Online Comment

Application H05-0303-22
Location 50 Fleet Road Fleet Spalding PE12 8LA
Proposal Residential Development of 25 Dwellings (Phase 2) outline approval H05-0468-18 (with access via Phase 1 approved by virtue of planning permission H05-1183-16)

Name Elaine Ferguson
Address Housing Strategy

Amendment 4 - Revisions to Plans: Revision to Housing Mix & Revised Sections (5366/KP/22/006 Rev P4 & 5366/KP/22/010 Rev P2)

Drawing Title: Phase 2 - Proposed Site Plan

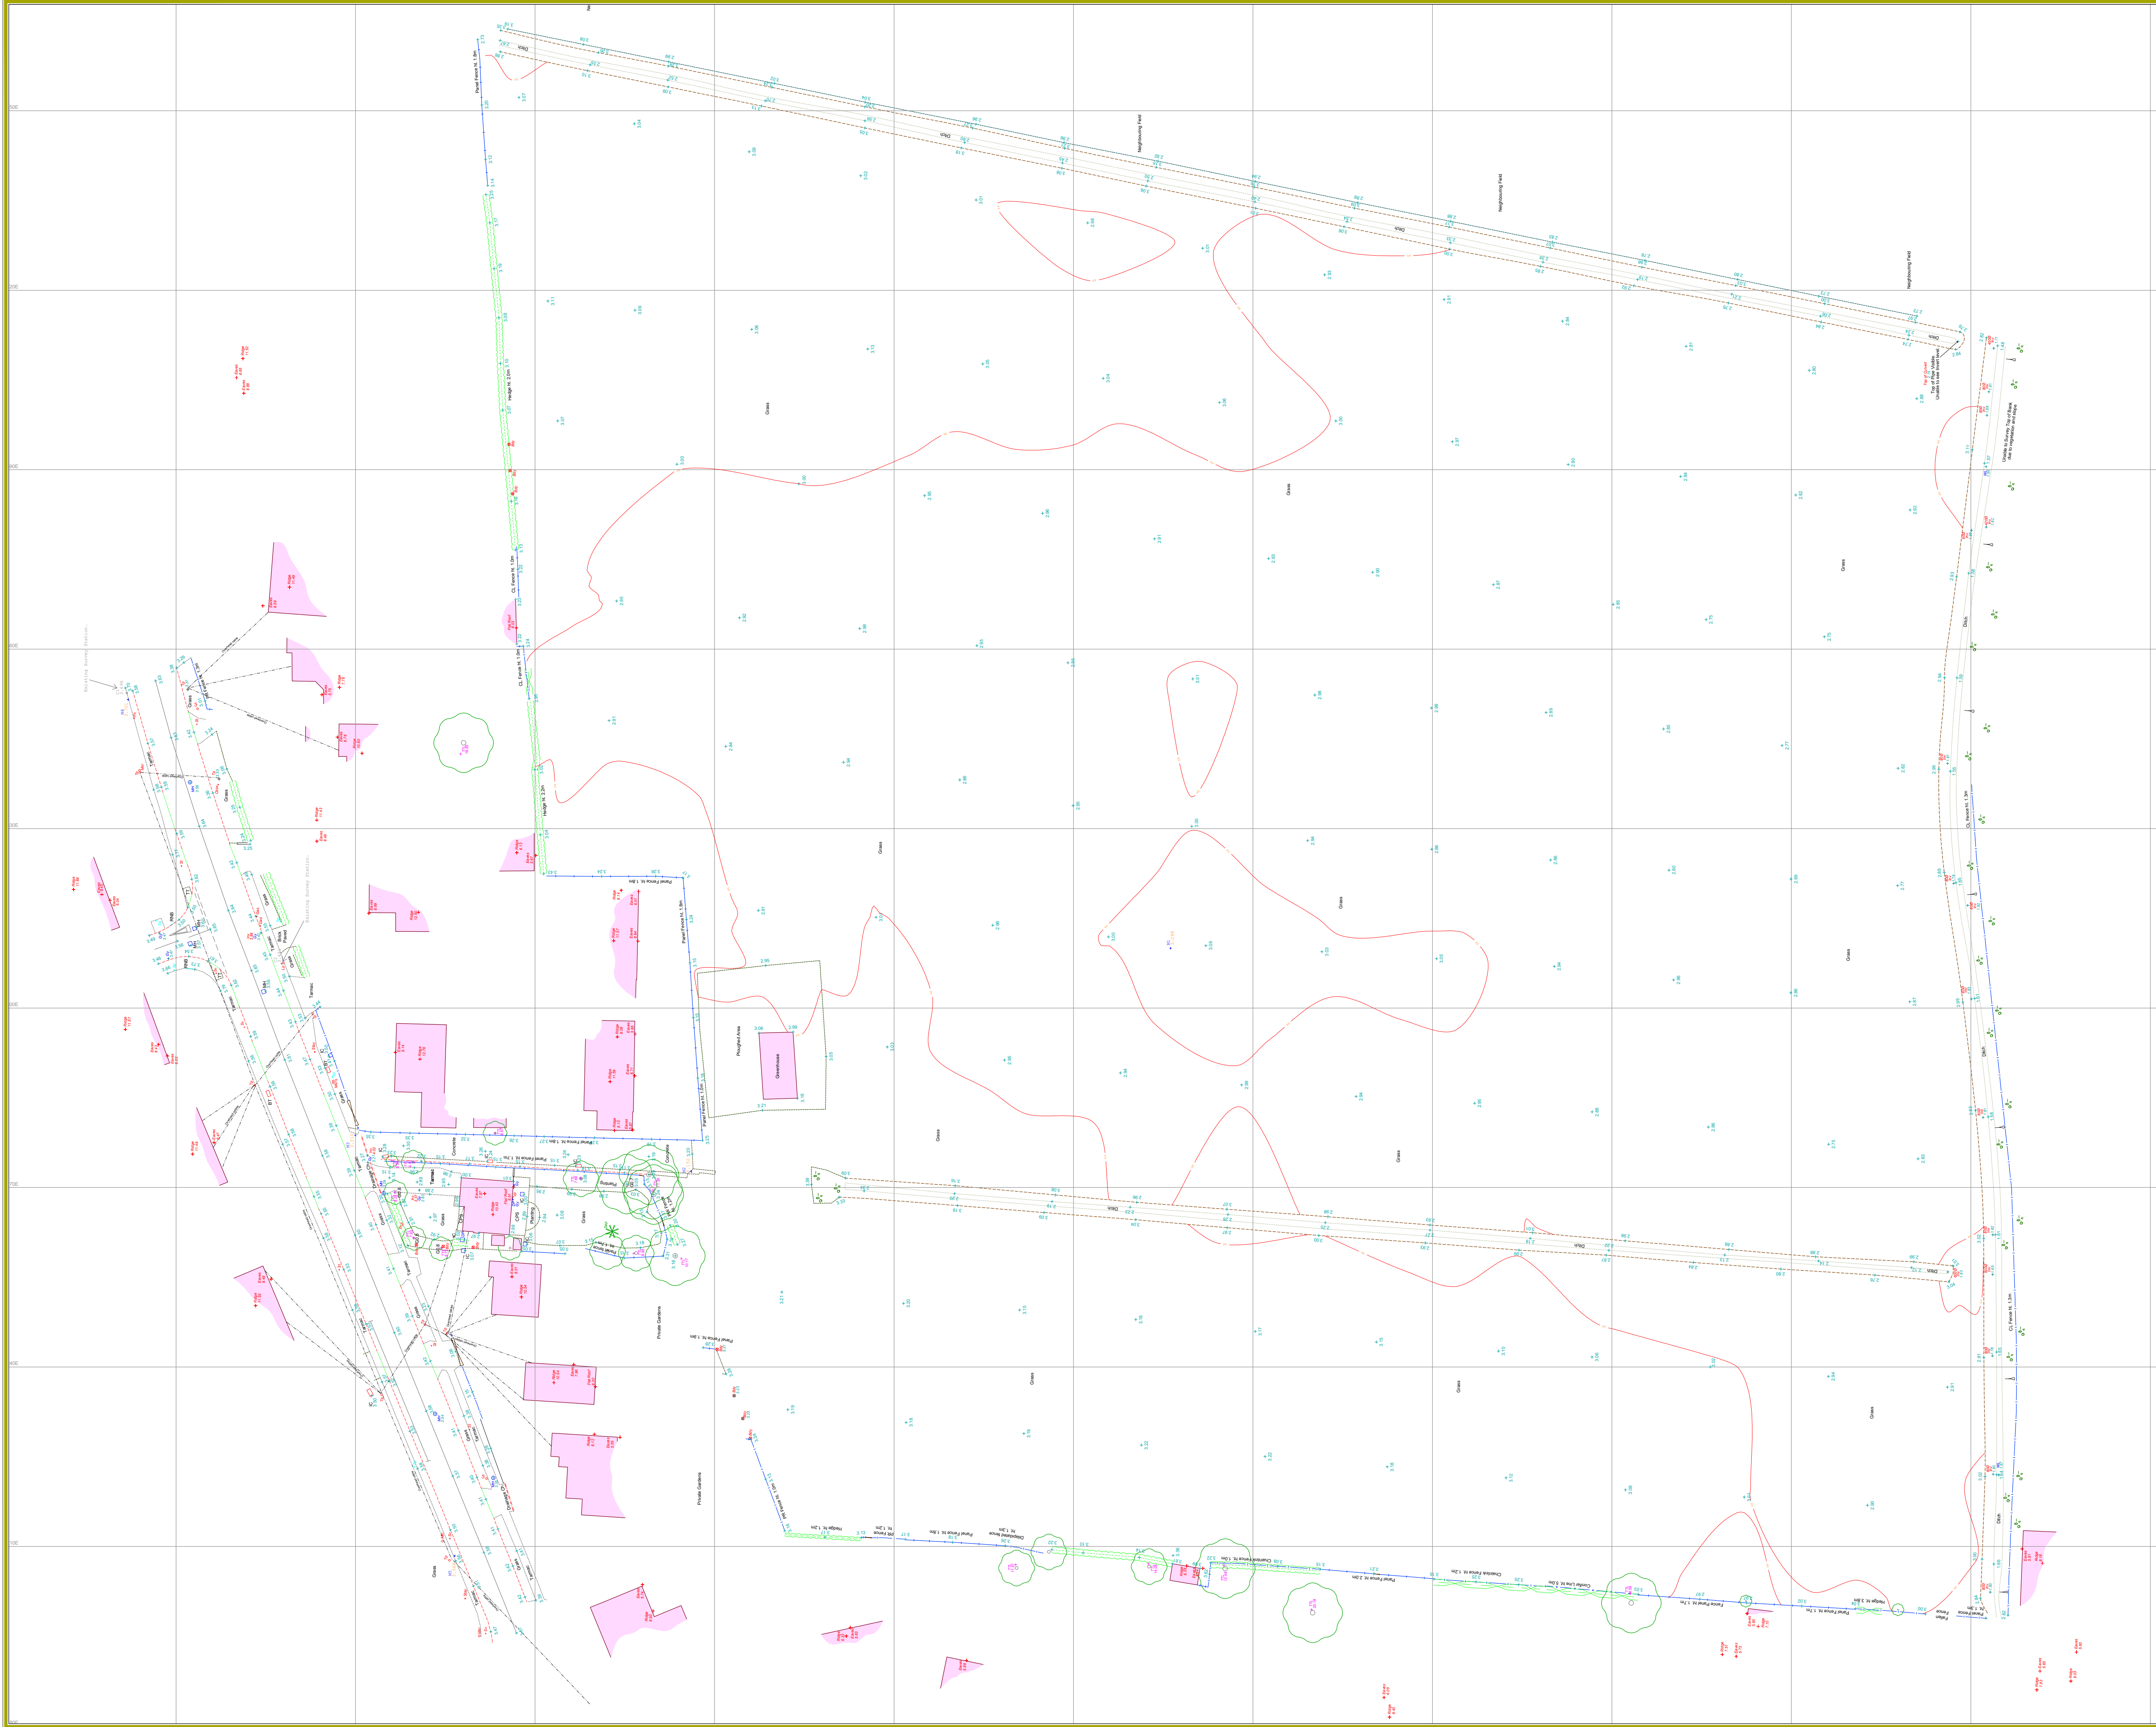
The applicant proposes an affordable housing mix as indicated on drawing 5366/KP/22?010 Rev P2 Phase 2 - Alternative Proposed Site Plan - Amendment 4. 25 affordable dwellings, 7 Affordable rented, 18 Intermediate Home Ownership - Share Ownership as set out below.

The applicant's affordable housing mix does not concur with the affordable housing mix previously provided by Housing Strategy. Whilst there is not a substantial supply of 3 bed shared ownership homes in the area. As regard the specific site there are already a substantial number of 3 bed shared ownership homes and in costly home buyer market 2 bed homes are preferable. We appreciate this is home purchase, the affordability of this tenure is a priority. Whilst there may be some flexibility between the numbers of 2 and 3 bed homes in the affordable home buying market, however there are already 16 across the development and a further 10 will take the number to 65% of the intermediate homes

offered. The South Holland Housing Needs Assessment information does not support this amount of 3 bed homes in preference to 2 bed homes.

We advise the applicant to contact Housing Strategy concerning the provision of the Intermediate Affordable Housing - Shared ownership homes.
